Rezoning Transportation Analysis

Petition Number: 2020-094

General Location Identifier: 14306126

Date	Description
08-12-20	First Review (Kevin Parker)

CHILDRESS, KLEIN  
DEVELOPMENT STANDARDS  
RZ1/2025  
REZONING PETITION NO. 2025

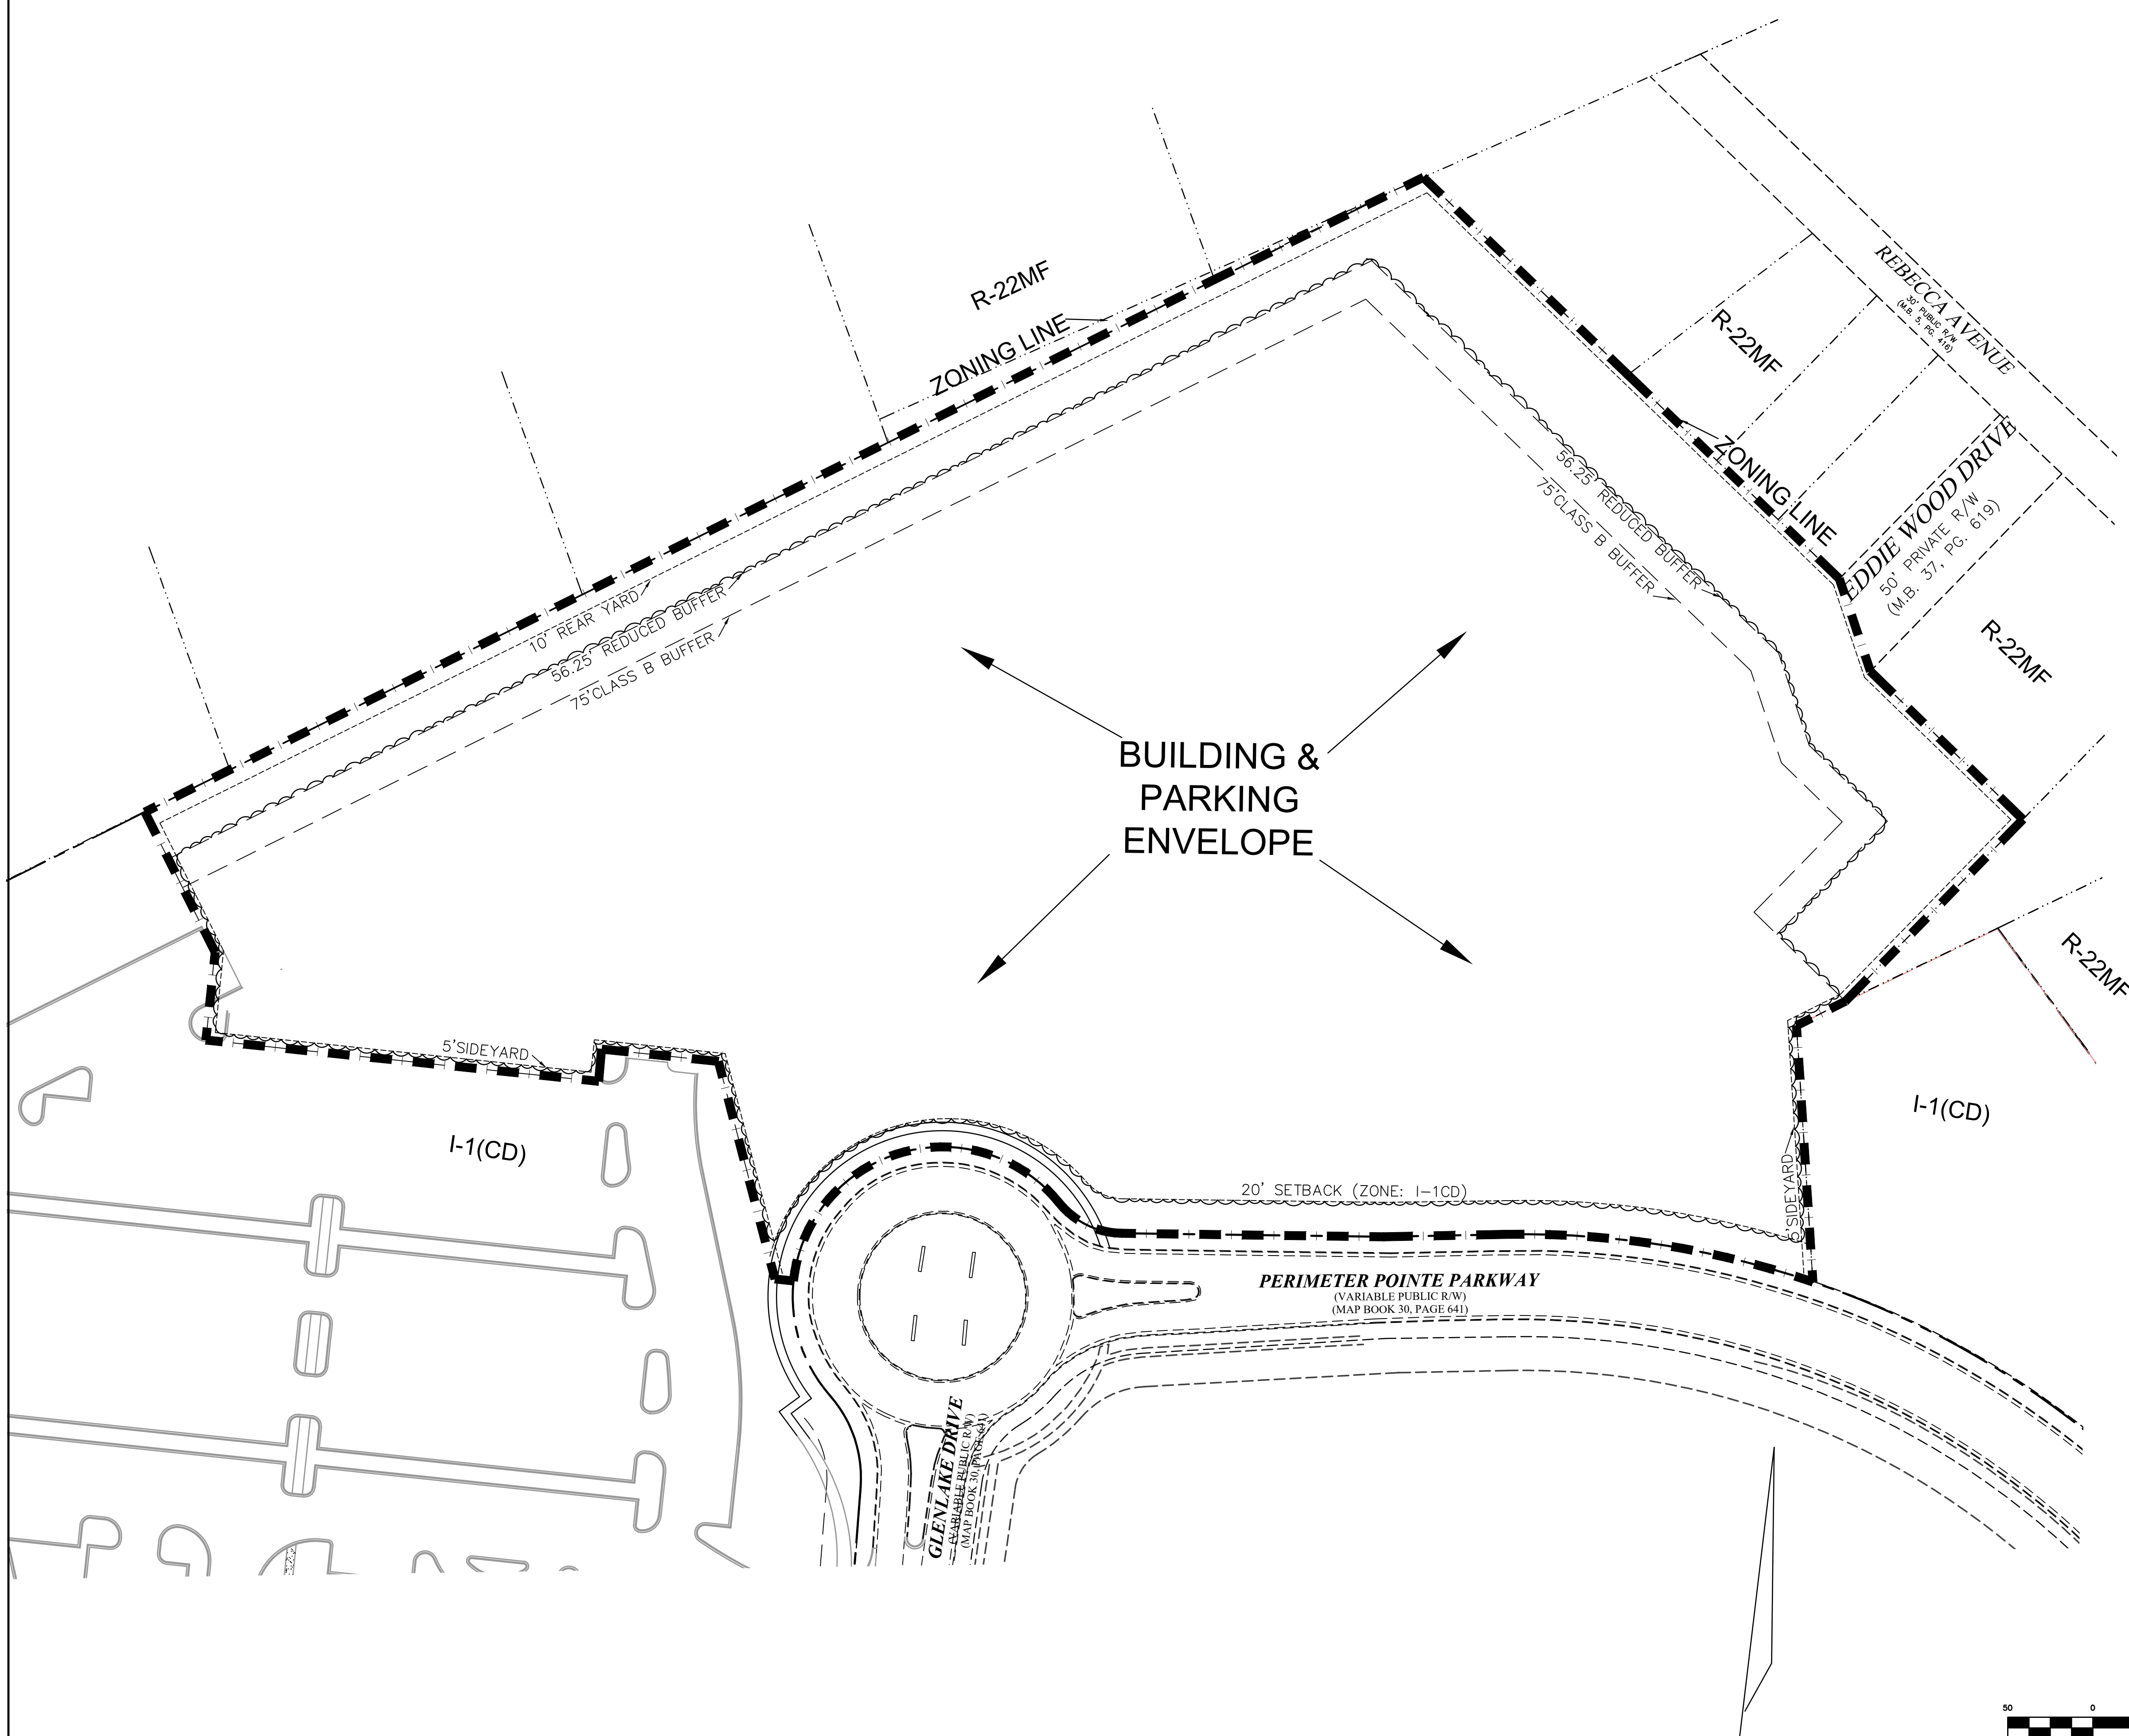
The site plan should show the curb and gutter labeled and dimensioned from the centerline for each road.

2. **Traffic Study:** A Traffic Impact Study is not necessary for the complete review of this petition.
3. In accordance with Charlotte WALKS, the petitioner should revise the site plan and conditional note(s) to commit to construct an 8-ft planting strip, and 6-ft sidewalk on Perimeter Pointe Parkway. This sidewalk should tie into the existing network at the adjacent parcel, 14306125, and extend to the curb ramp at Tyvola Road. The site plan should label and dimension both items from the back of curb and gutter and road centerline.

5. The petitioner should revise the site plan and conditional note(s) to clarify access point(s). The petitioner should have at least one access point that stems off the roundabout, creating the third leg. Turning movements should be performed to ensure the roundabout may function for the petitioner's design vehicles.

6. The petitioner should revise the site plan to add a note specifying dedication and fee simple conveyance of all rights-of-way to the City before the site's first building certificate of occupancy is issued. CDOT requests right of way set at 2 feet behind back of sidewalk where feasible.

7. The petitioner should revise the site plan to add a note specifying all transportation improvements will be approved and constructed before the site's first building certificate of occupancy is issued. The petitioner may phase transportation improvements if said improvements and phasing are explicitly described in site plan notes.
